June 10, 2015

**RE: Warehouse, 4455 Anaheim  
Grading and Drainage Plan  
Engineer's Stamp Date 5-13-2015 (File: C17-D123)**

Based upon the information provided in your submittal received 5-14-15, the above referenced plan cannot be approved for Building Permit until the following comments are addressed:

ENGINEER'S SEAL	4455 ANAHEIM	DRAWN BY WCWJ
	GRADING AND DRAINAGE PLAN	DATE 6-11-15
		21515-LAYOUT-5-03-15
DAVID SOULE P.E. #14522		SHEET #
		JOB # 21515

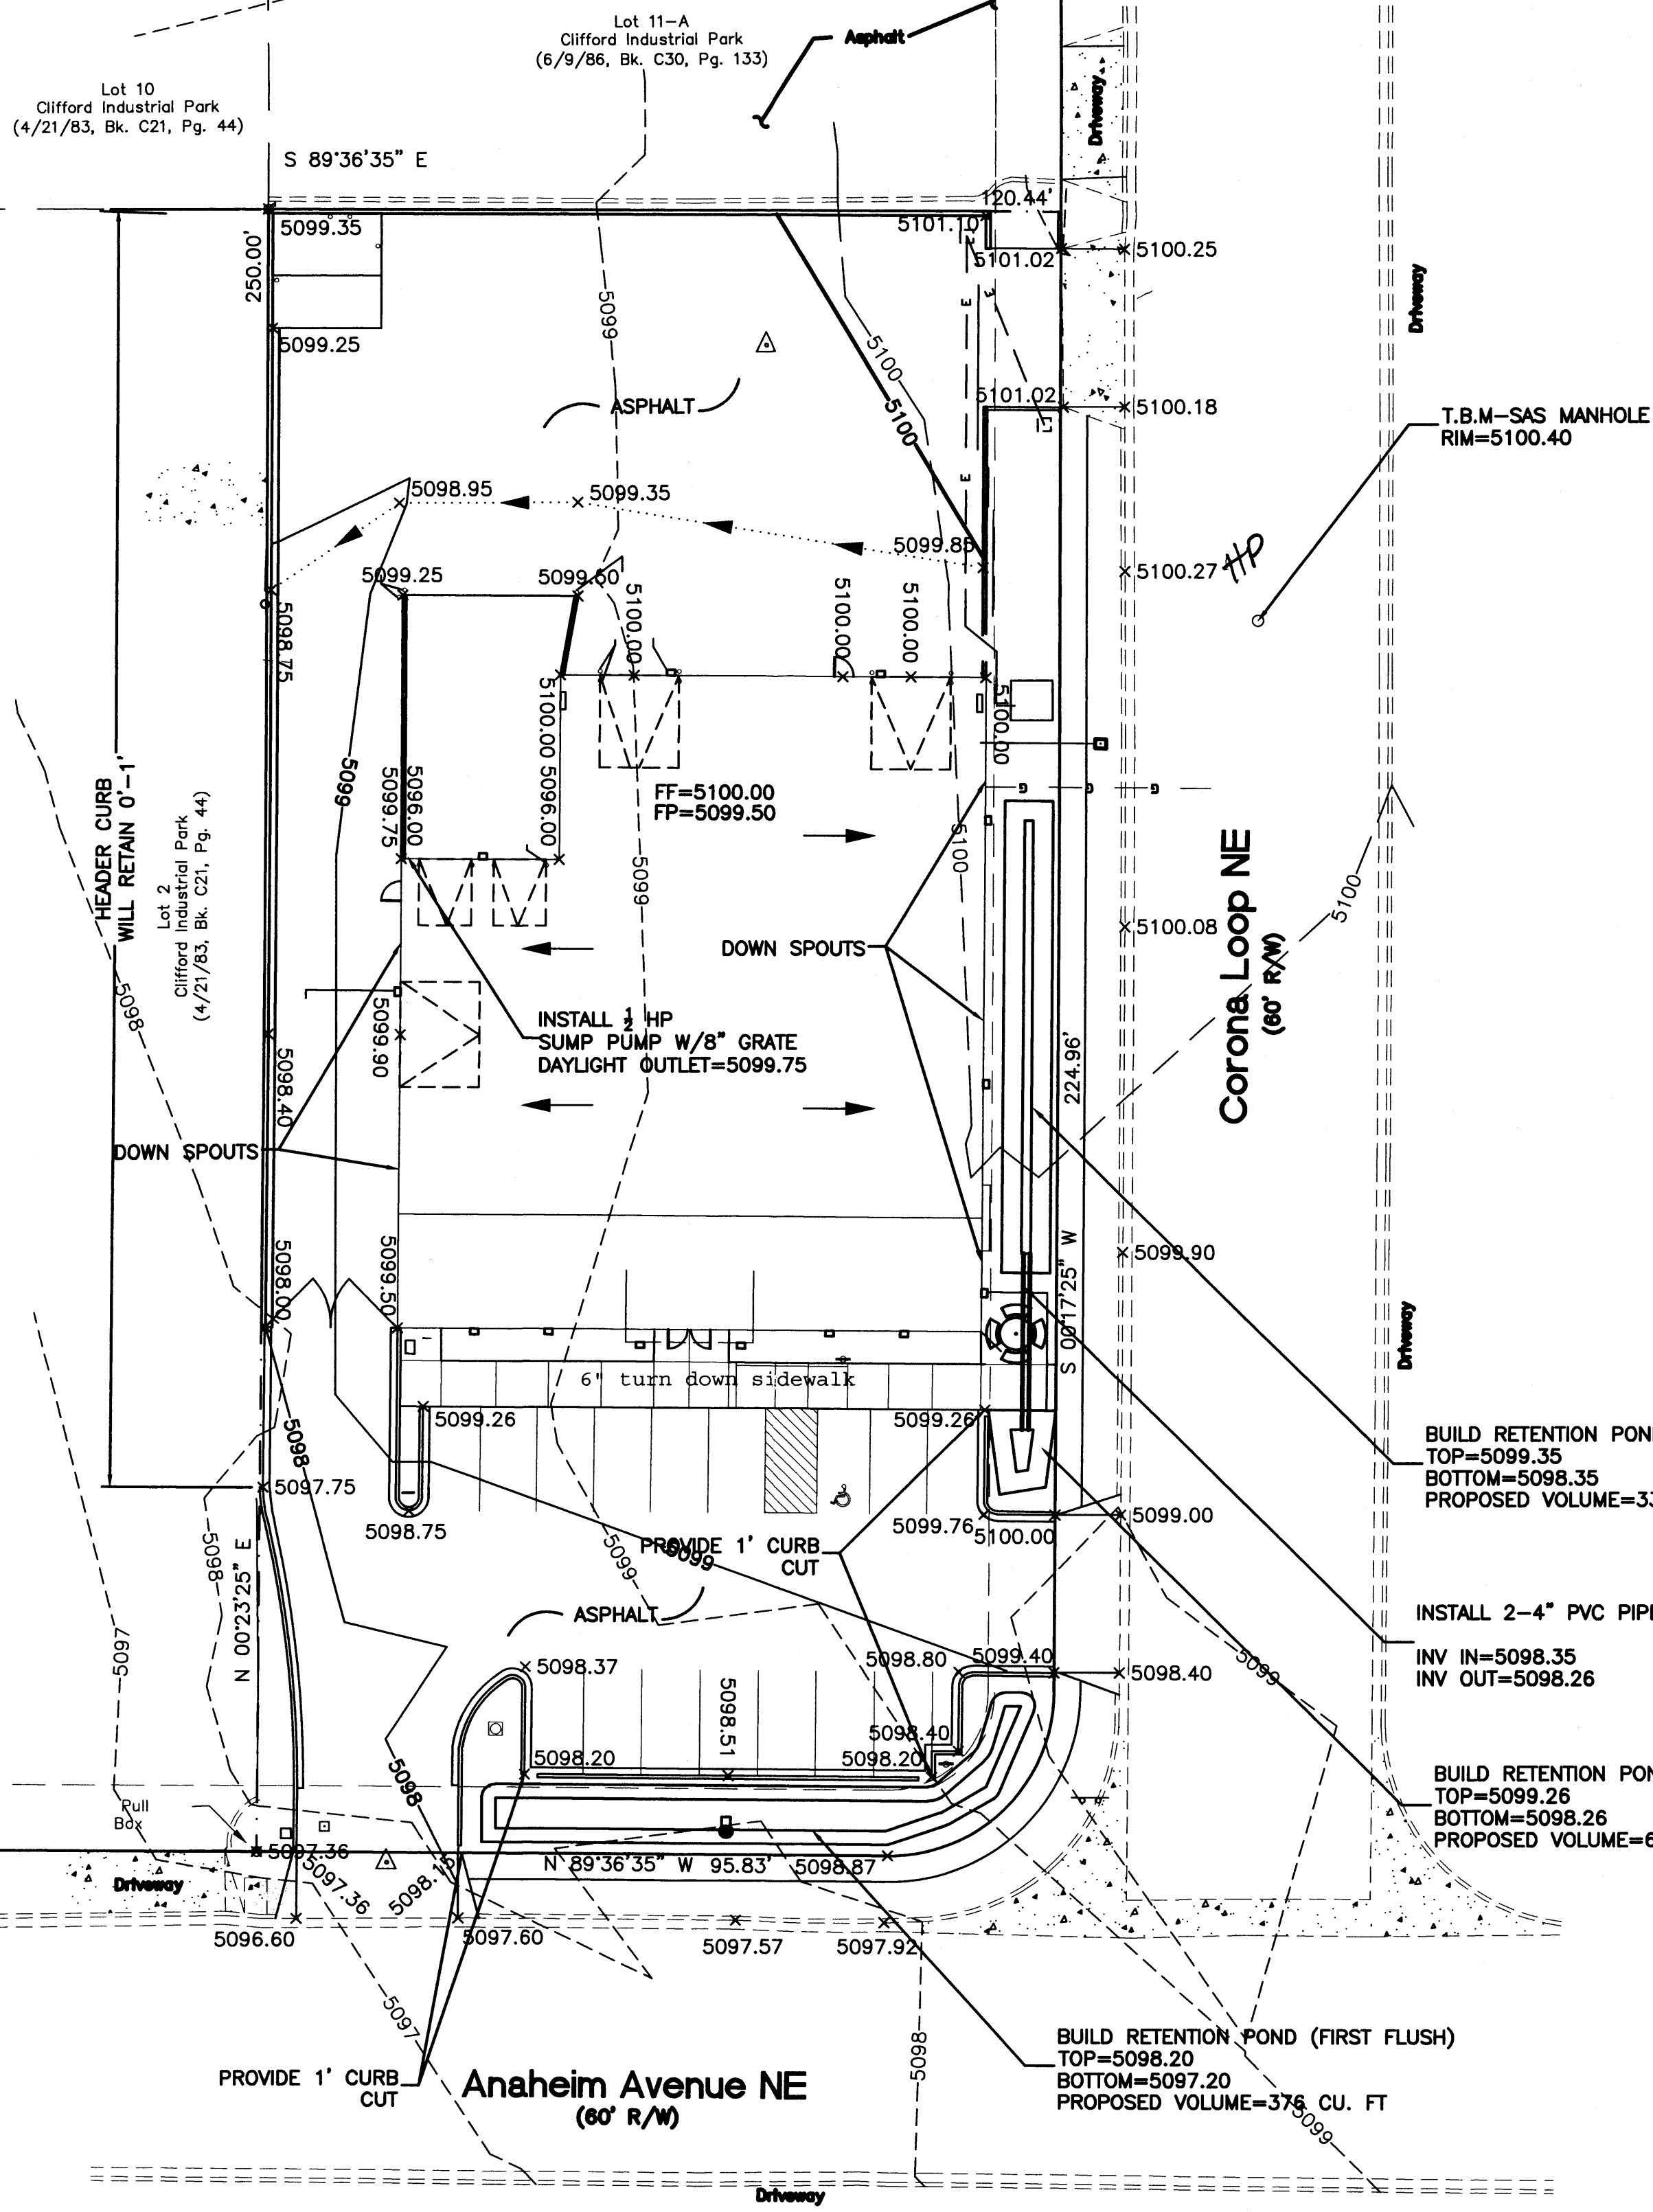
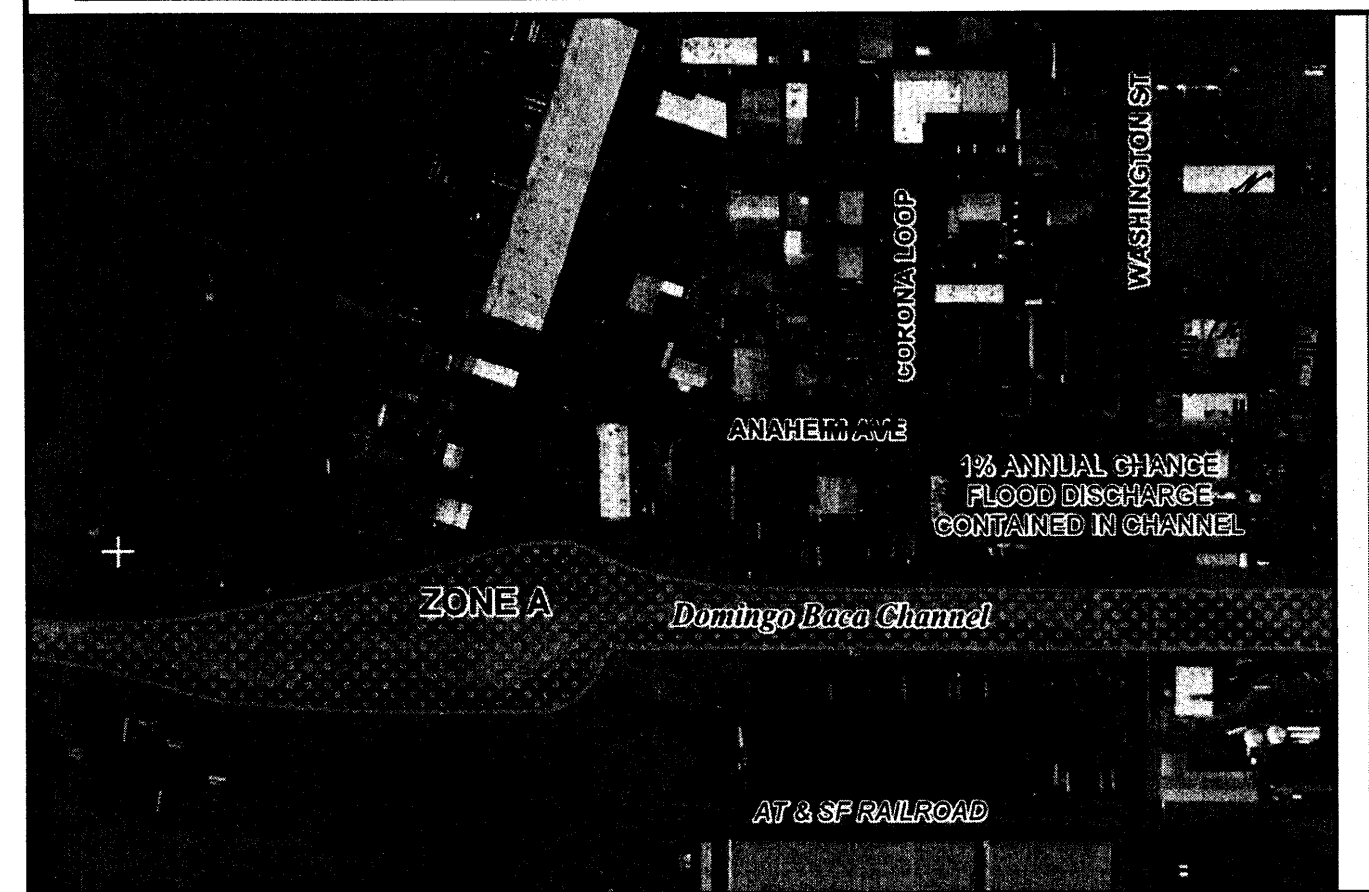
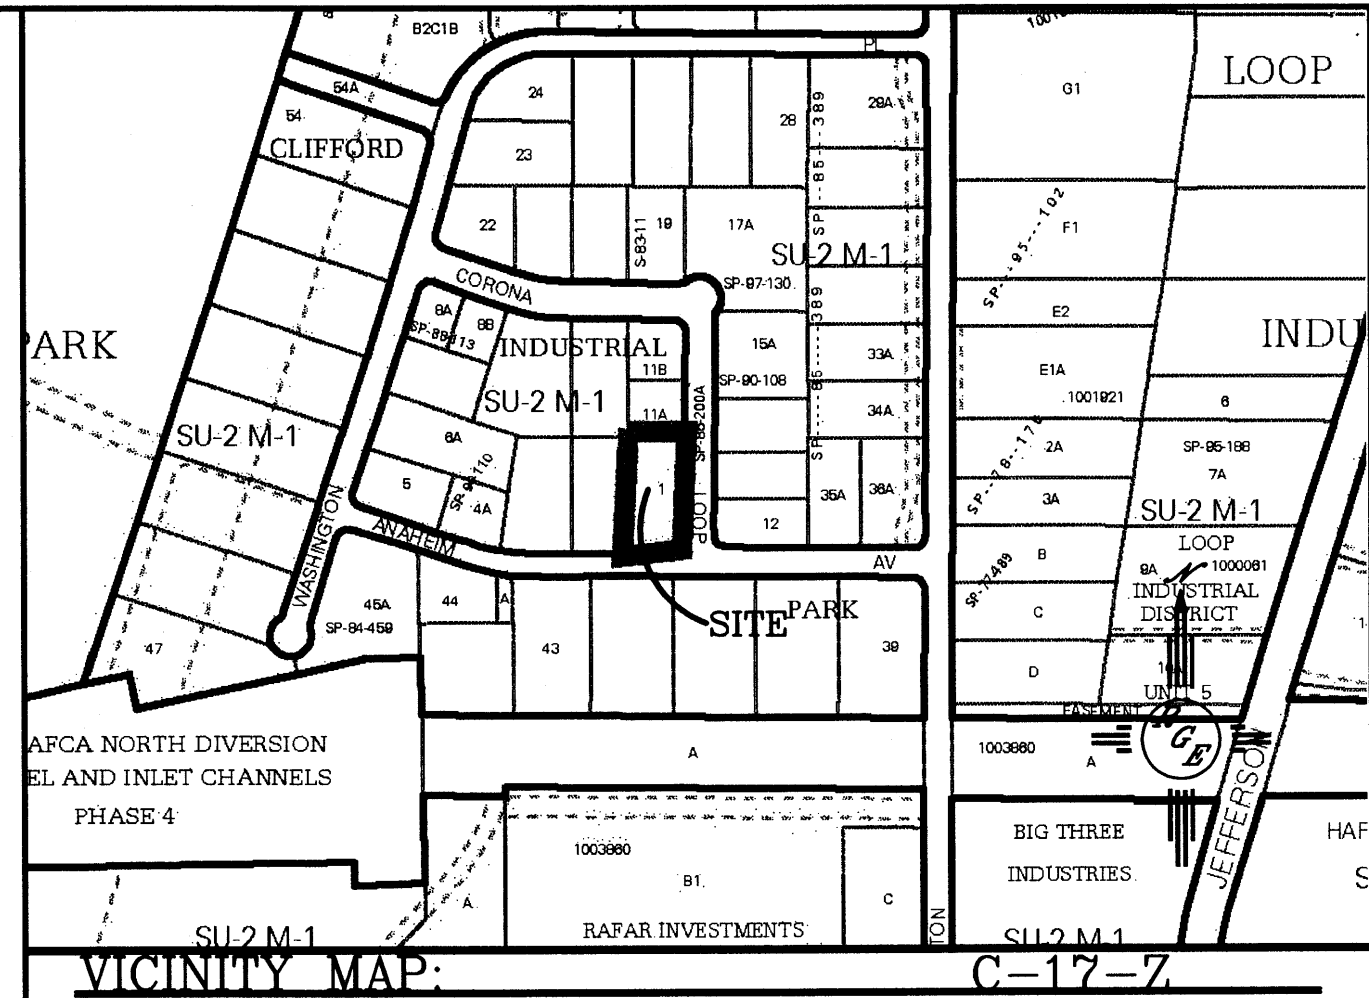
- 1) Provide new and existing curb linetypes and building boundary within legend. Label any gravel areas as "gravel" and paved areas as "paved", and count gravel lot areas as land treatment type "C". Label any new curb and curb height on the plan view as applicable.
- 2) Show roof drain locations.
- 3) Show existing spot elevations for curb on Corona Loop and on Anaheim Avenue. Label proposed contours, and additionally provide boundary lines around each of the pond areas that define the top and bottom elevations of the pond. For the three retention ponds, indicate that they are for the "first flush" if this is the case. If new spot elevations provided are at flowline of curb, provide general note stating this.
- 4) Correct minor discrepancy in the drainage report which shows a discharge of 2.93 cfs under "Proposed Conditions" discussion and 2.36 cfs under "Summary and Recommendations".
